# STERLING RANCH FILING NO.2

### GRADING & EROSION CONTROL PLAN

#### JANUARY 2021

Engineering Review

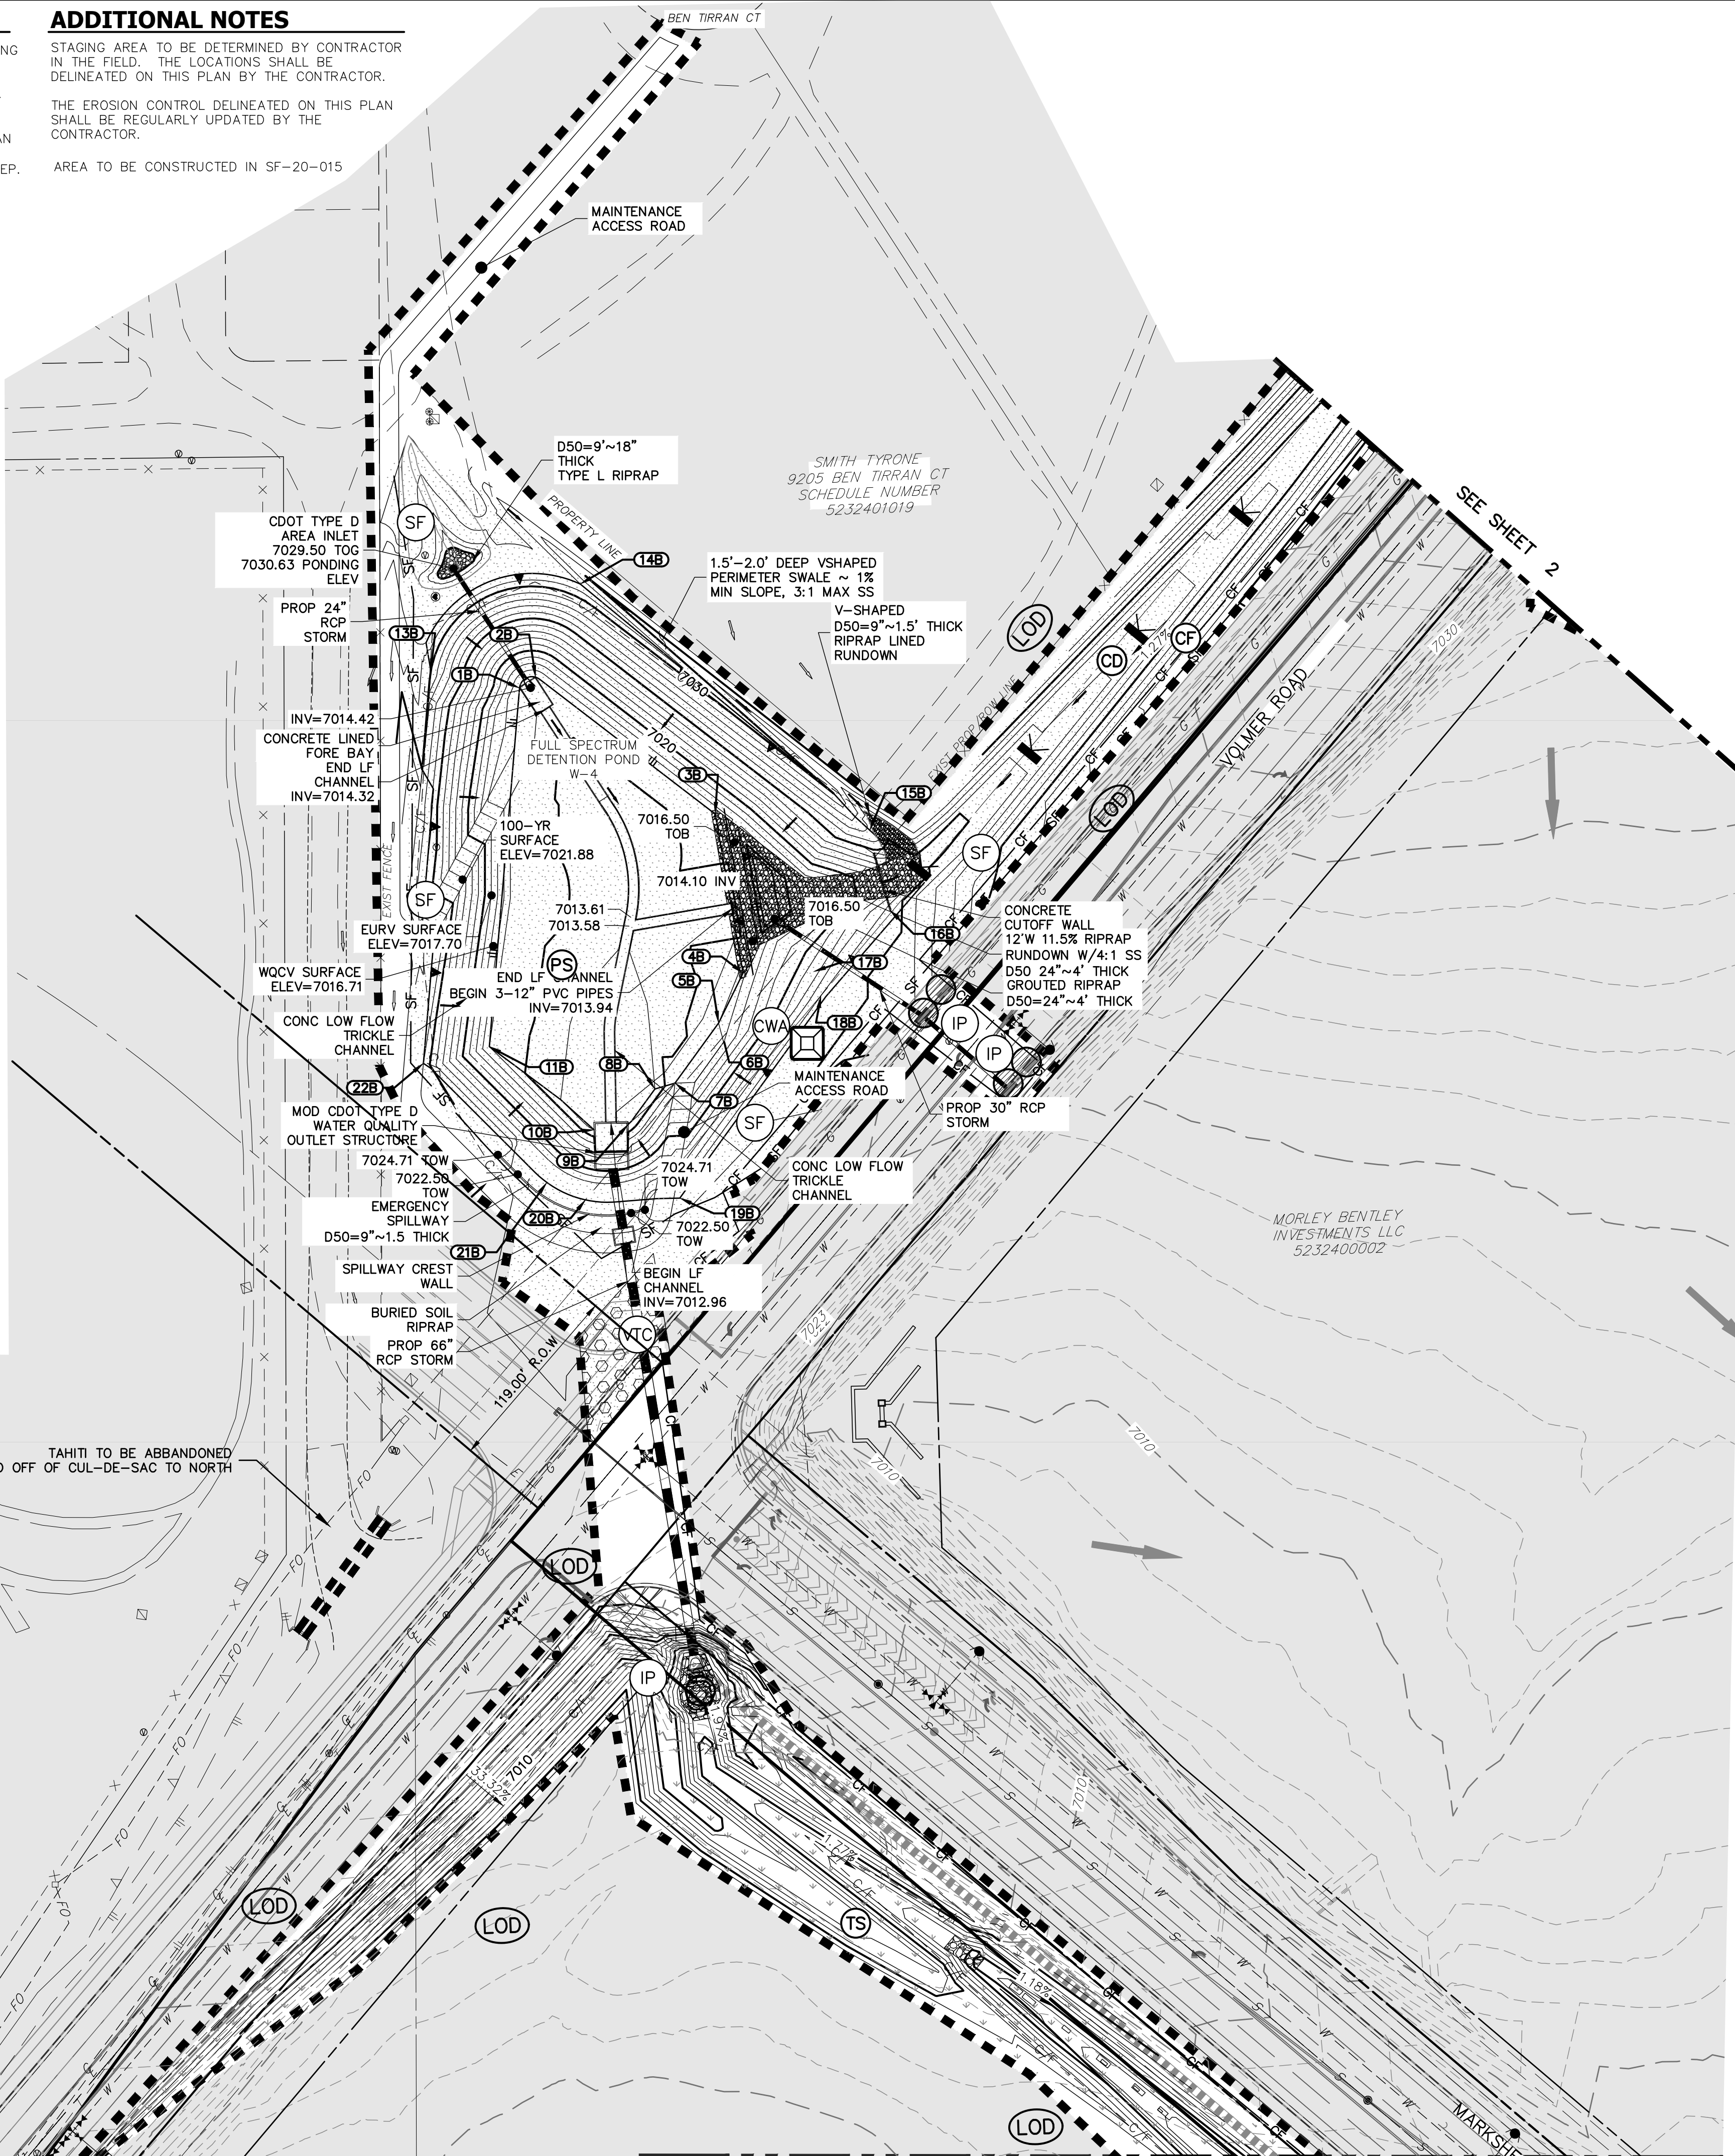
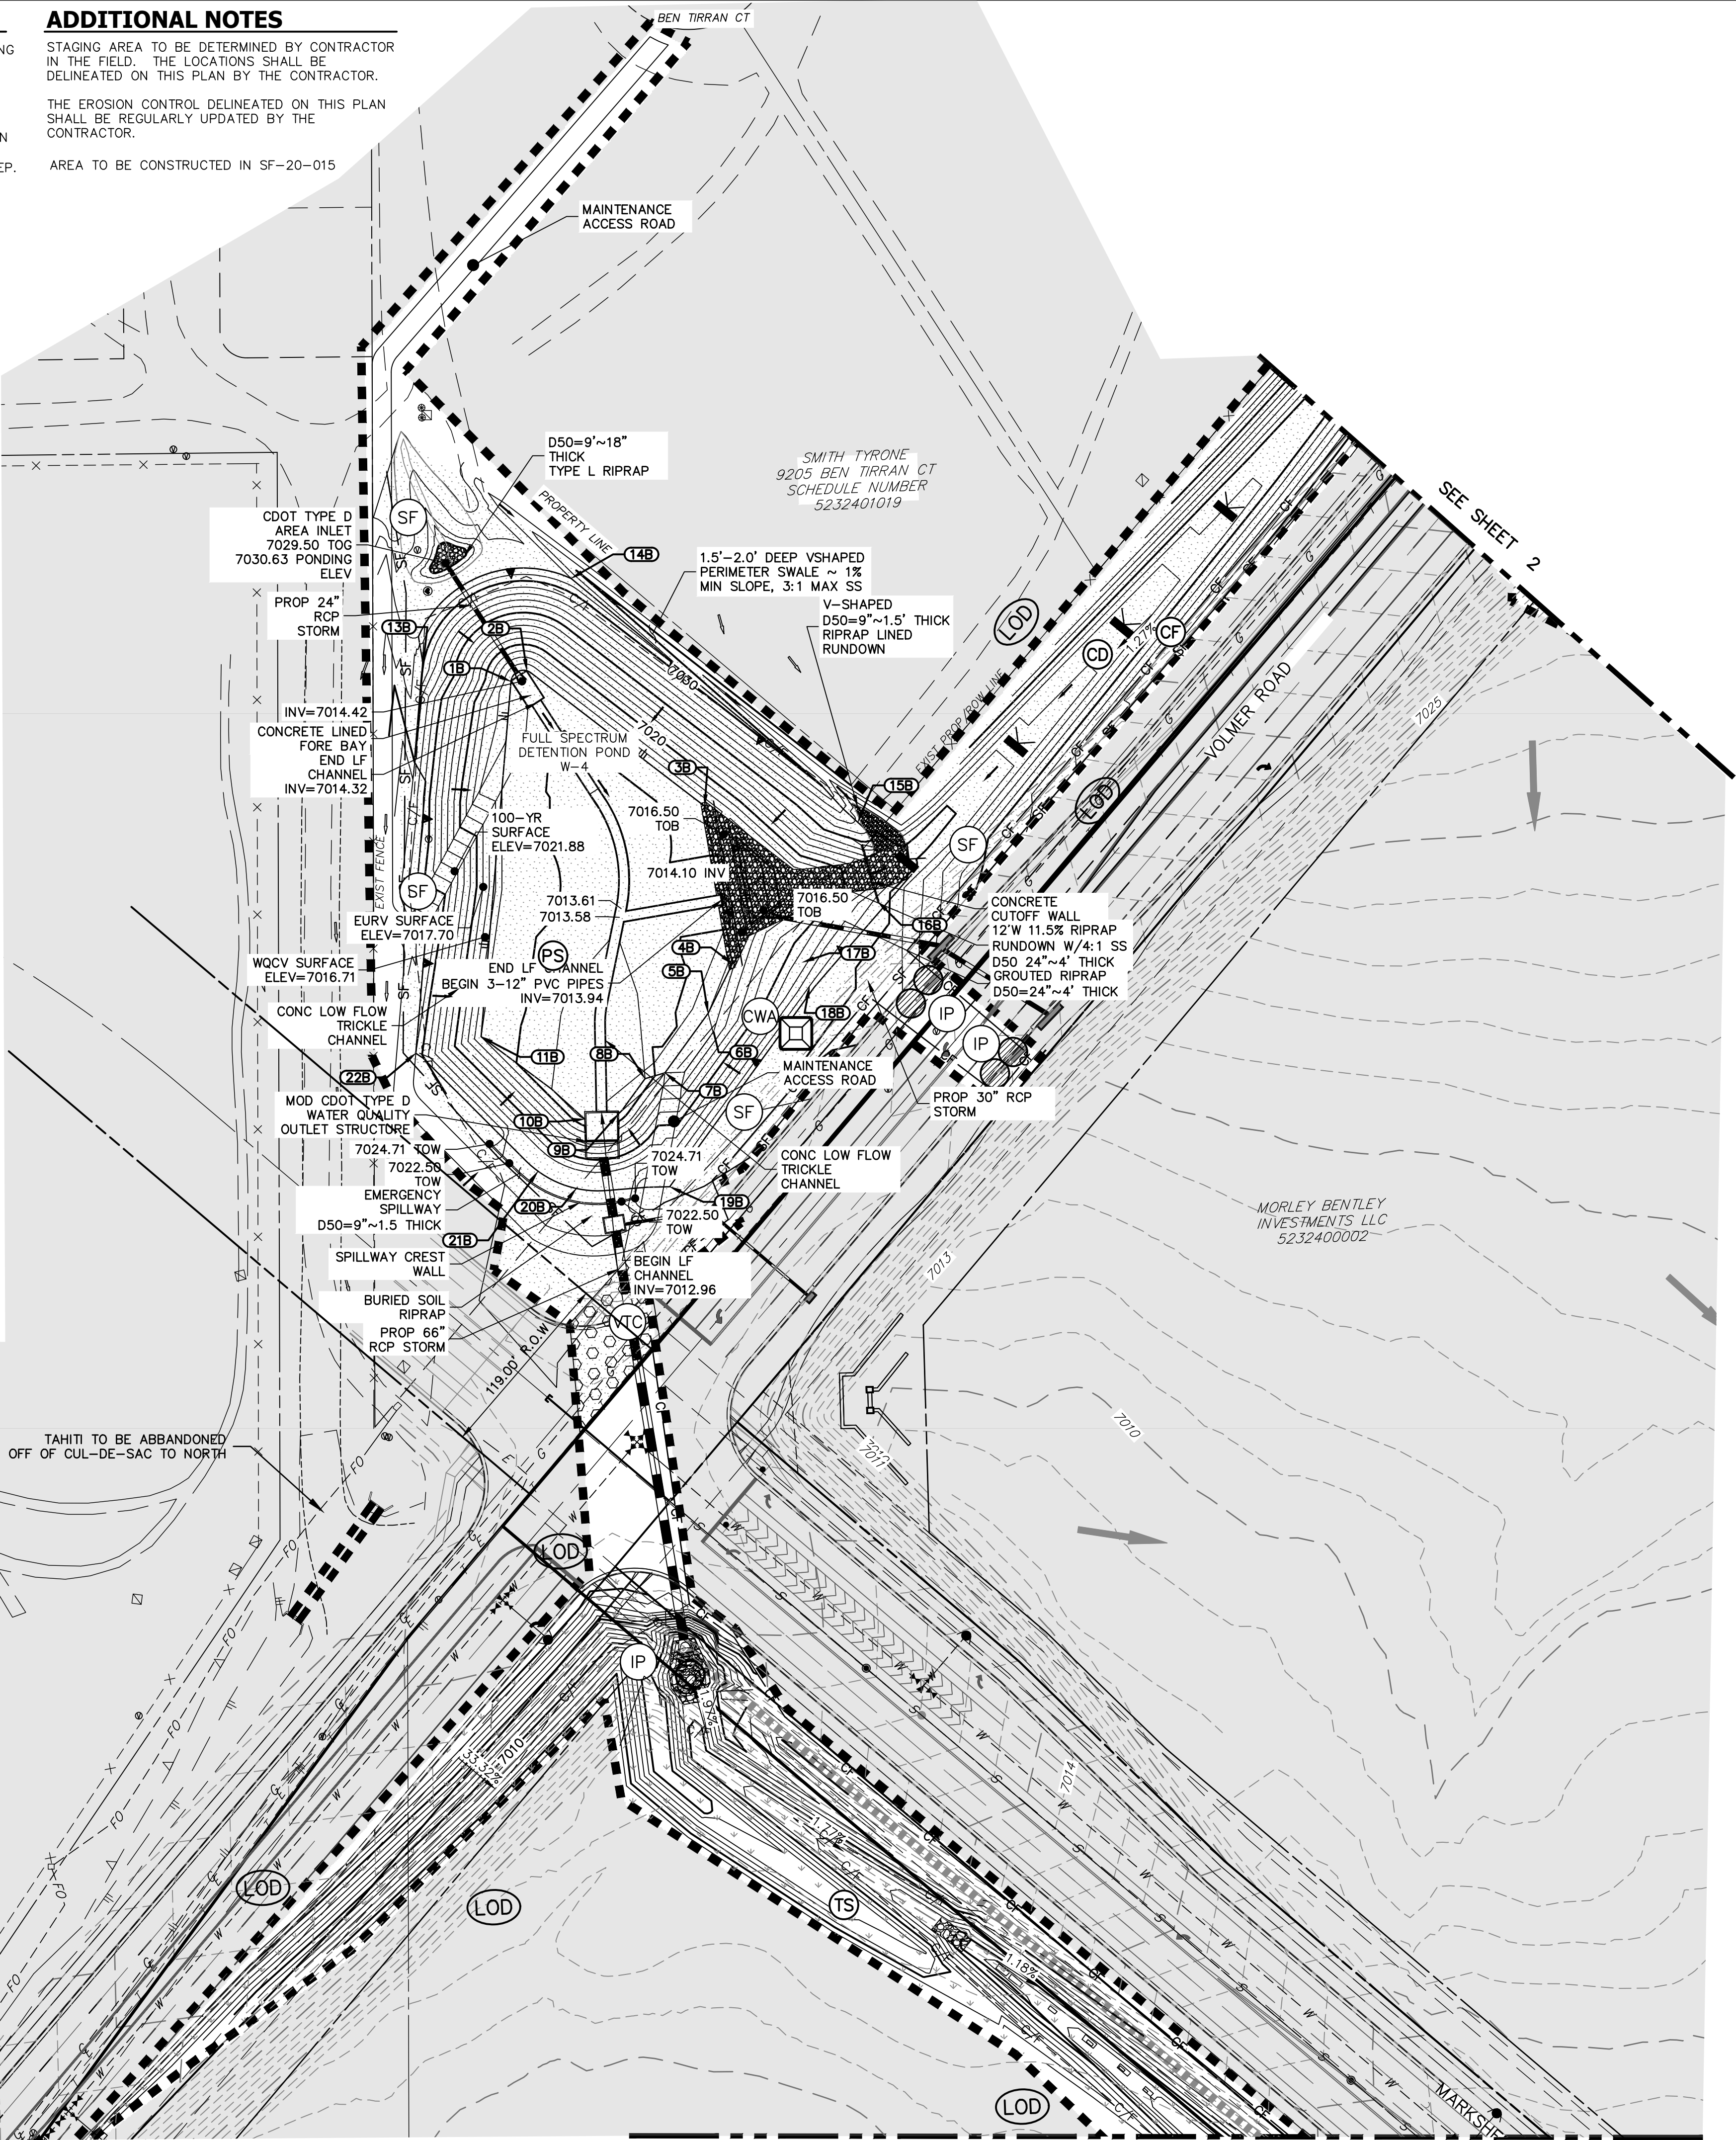
CWA should be away from the ditch

ROW doesn't seem wide enough for turn lanes...

show construction fence in legend

Is scale correct?

JR RESPONSE: CWA moved away from the ditch

JR Response: Future road now shown and R.O.W label adjusted

JR Response: Construction fence is now shown on the legend

JR RESPONSE: Yes, scale was incorrect
